From: Bloomer, David <David.Bloomer@lancashire.gov.uk>
Sent: 30 November 2018 10:28
To: Rebecca Bowers
Cc: LHS Customer Service; planning
Subject: app3/2018/01032 Pyethorn Meadows Wilpshire

This proposal has had a number of iterations due to my concerns that the visibility splays for emerging vehicles was unsatisfactory. Based on the results of a speed survey carried out in the vicinity which showed 85th %ile speeds of 38mph in an easterly direction and 37mph in a westerly direction the appropriate to the visibility splays would be 60m and 58 metres left and right on exit respectively. The applicant quotes a visibility splay of 2.4 x 30.6m to the right which falls short of the required 58m. However, the "x" distance (setback from the back of the footway) can be reduced to 2m due to the nature of the development and with this in mind together with the removal of the hedge and the horizontal alignment of Whalley Road a visibility splay in excess of the required 58m can be achieved.

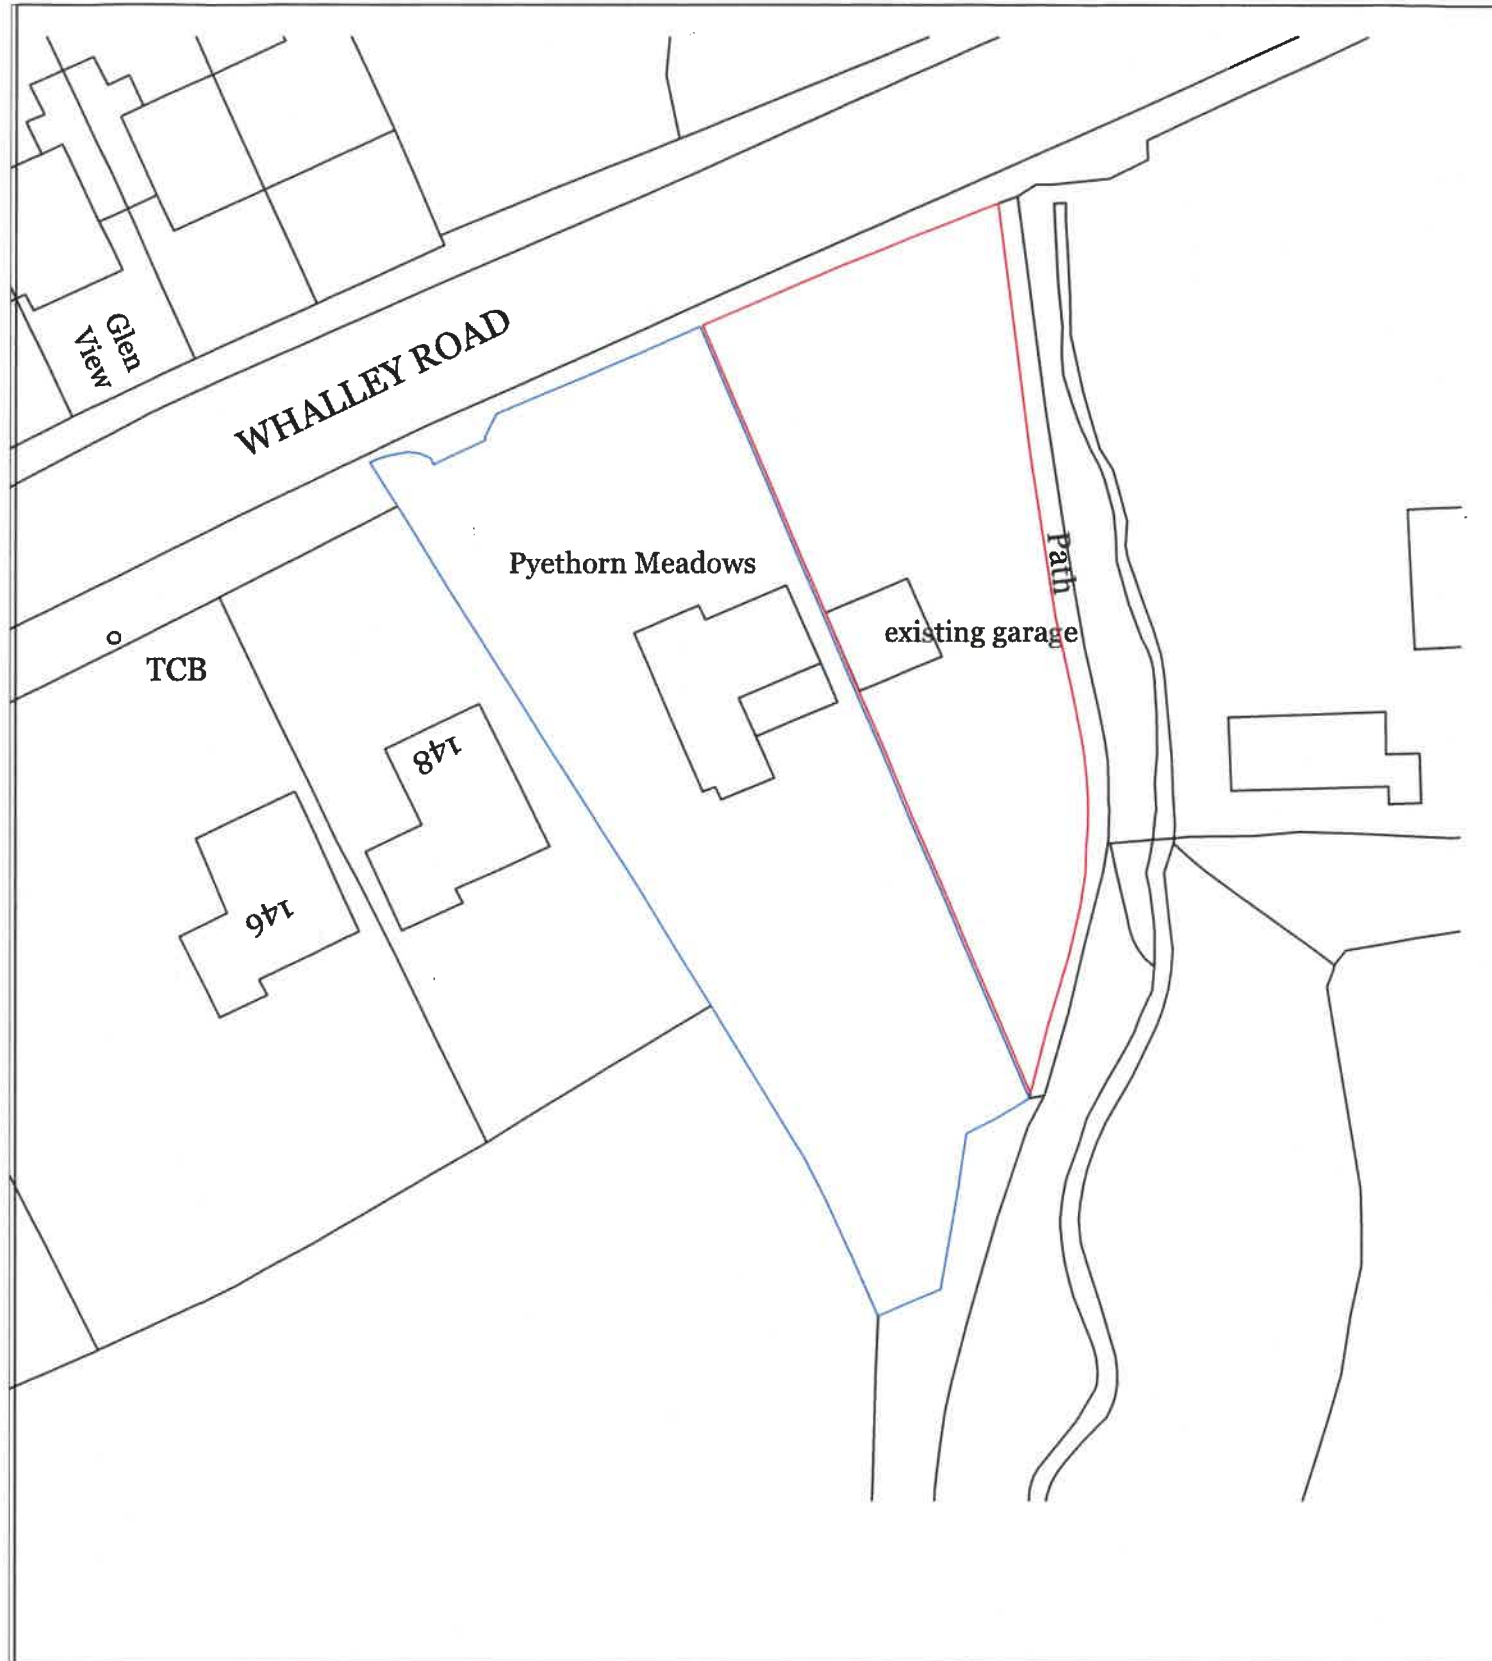
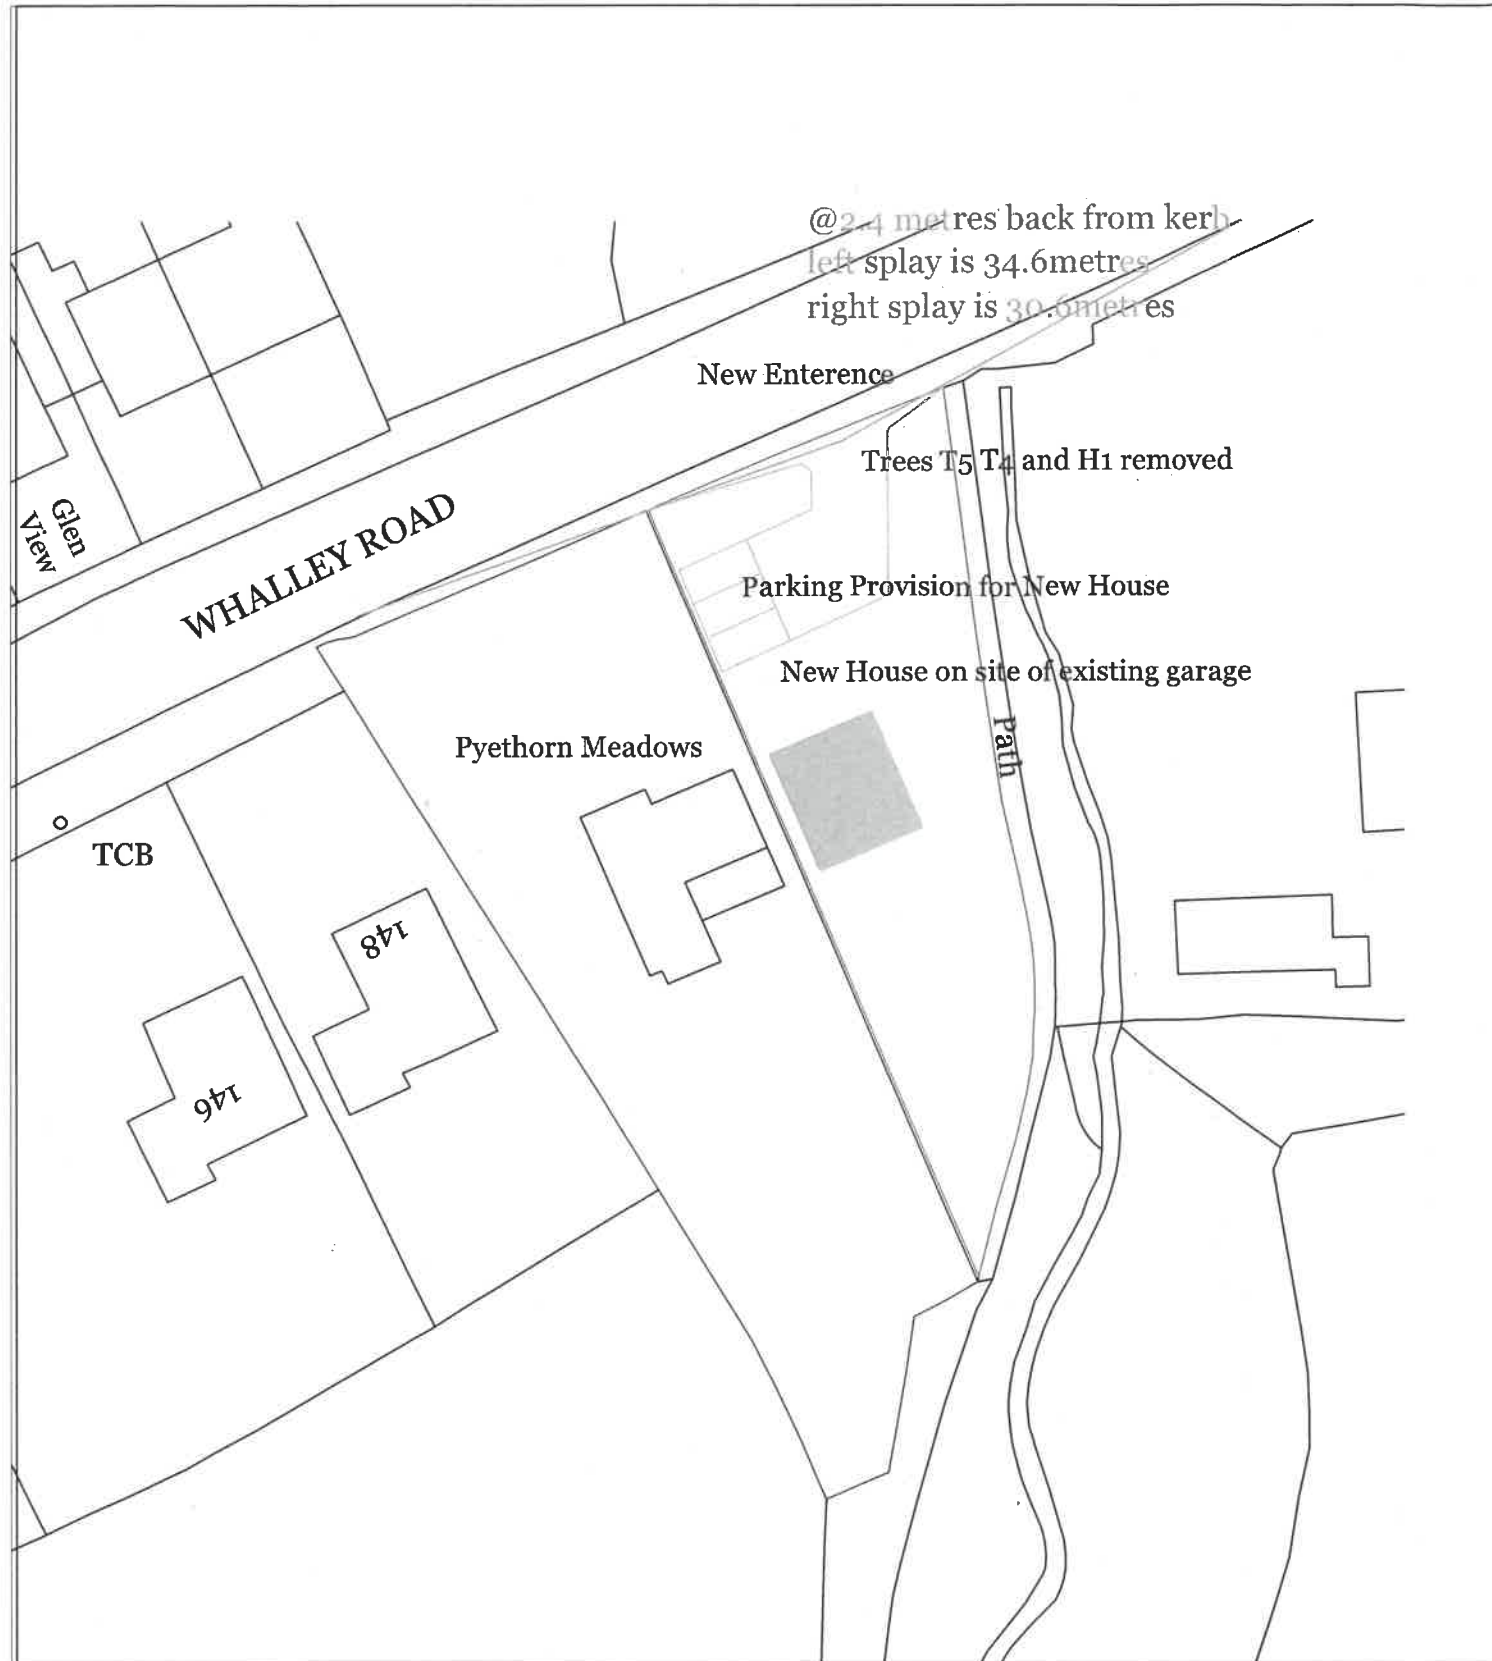
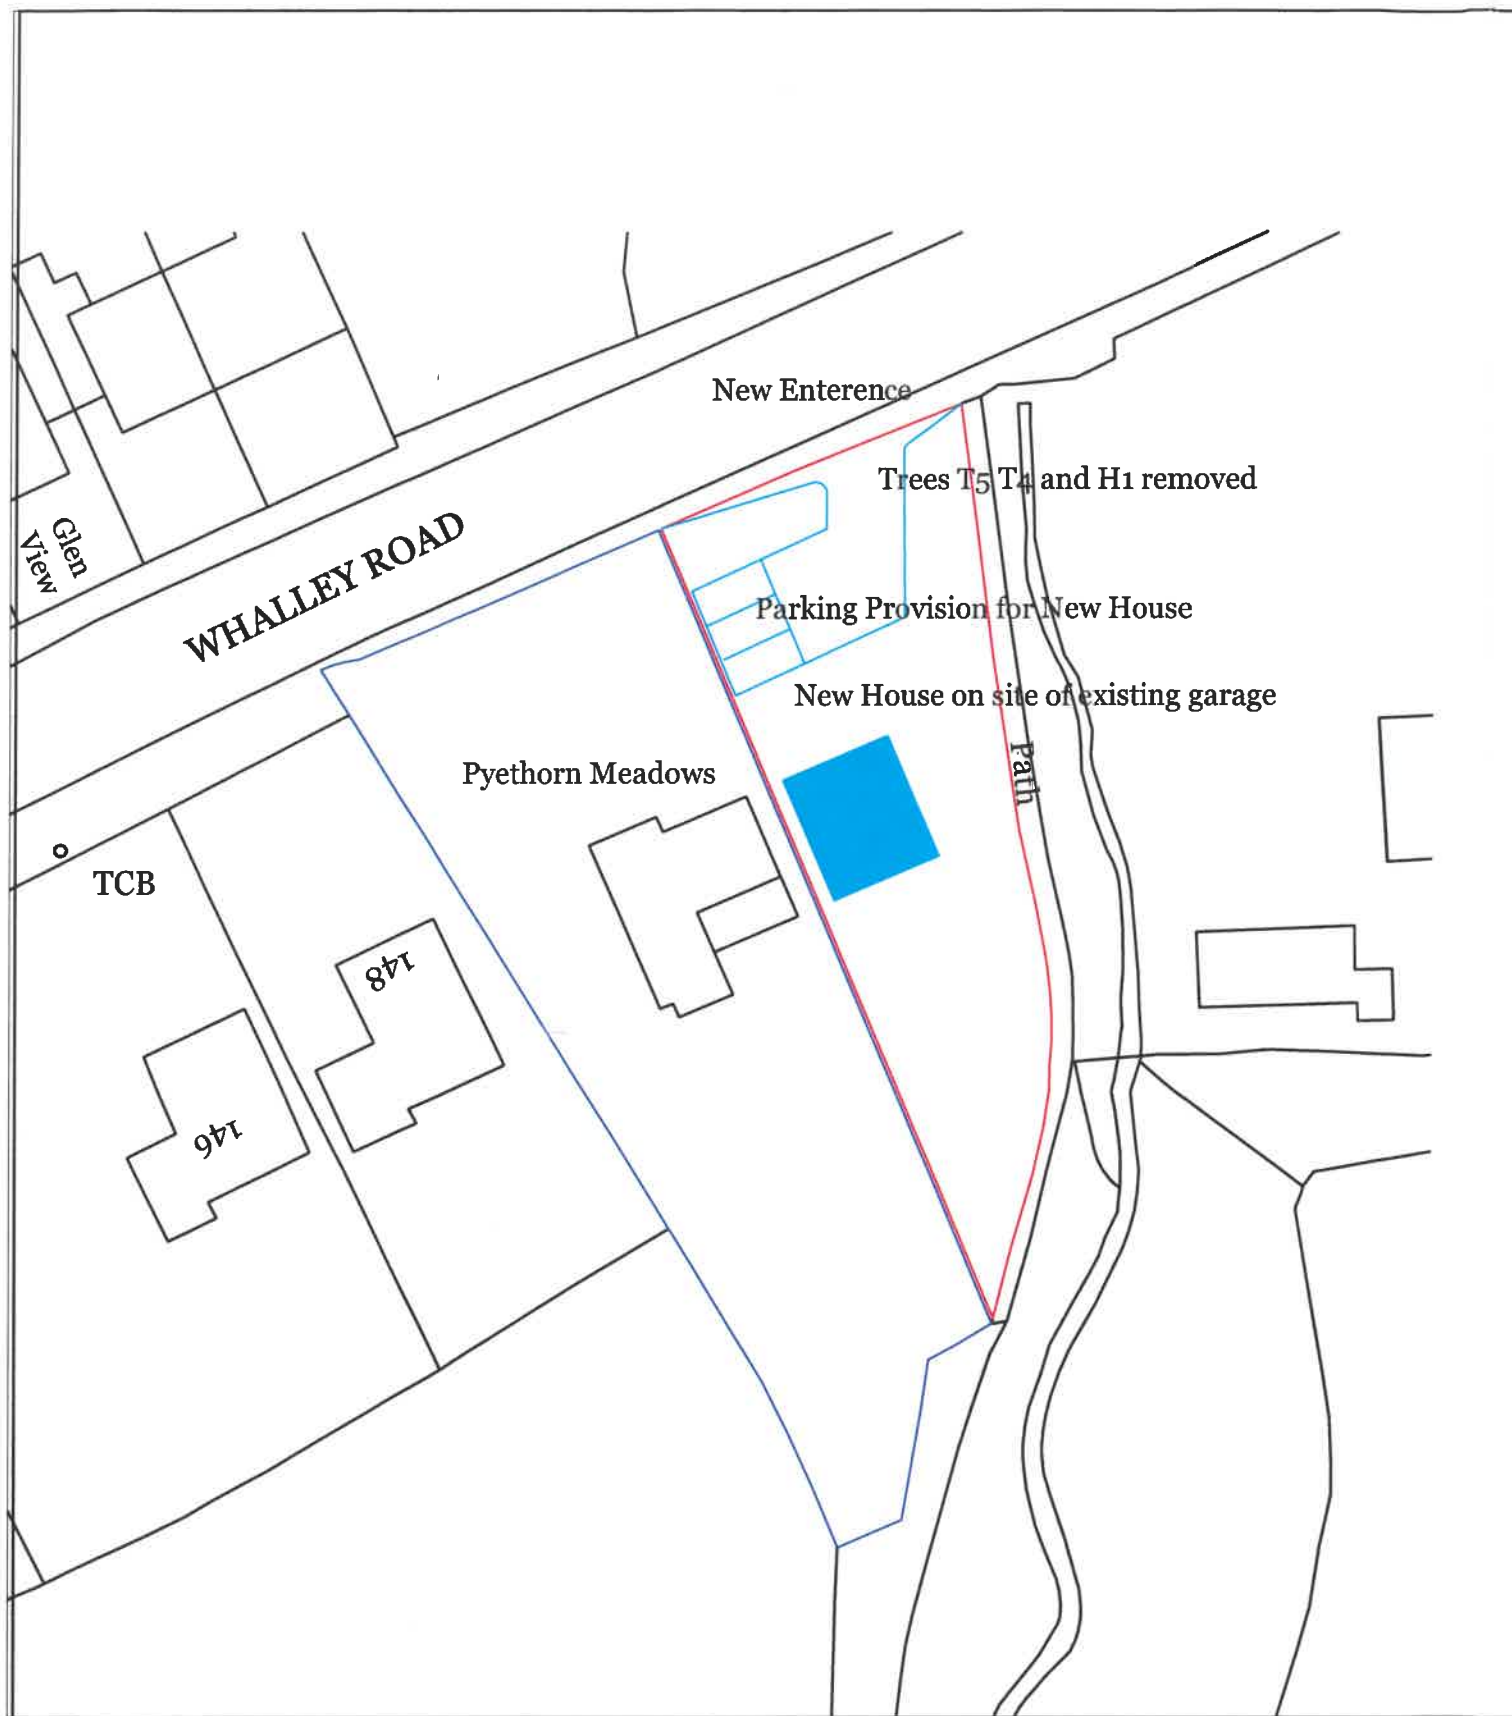
Turning to the visibility requirements for the left, the visibility splay dictated by the 85th %ile speed recorded is 60m. The applicant suggests that 34.6m is achievable. If a 2m "x" distance is used this increases to 36m. In order to achieve the required 60m it would be necessary to remove / reposition an additional section of the hedge fronting Pyethorn Meadows along with the possible removal of tree T2. As this is achievable as it is within the ownership of the applicant, I would raise no objection to the proposal subject to the following conditions being attached to any permission that may be granted.

1. Notwithstanding the provisions of the Town and Country Planning (General Permitted Development) Order 1995 there shall not at any time in connection with the development hereby permitted be erected or planted or allowed to remain upon the land hereinafter defined any building, wall, fence, hedge, tree, shrub or other device over 1m above road level. The visibility splay to be the subject of this condition shall be that land in front of a line drawn from a point 2m measured along the centre line of the proposed road from the continuation of the nearer edge of the carriageway of Whalley Road to a point measured 60m in a westerly direction and 58m in an easterly direction along the nearer edge of the carriageway of Whalley Road, from the centre line of the access. Reason: To ensure adequate visibility at the street junction or site access.

2. Before the access is used for vehicular purposes, that part of the access extending from the highway boundary for a minimum distance of 5m into the site shall be appropriately paved in tarmac, concrete, block pavements, or other approved materials. Reason: To prevent loose surface material from being carried on to the public highway thus causing a potential source of danger to other road users.
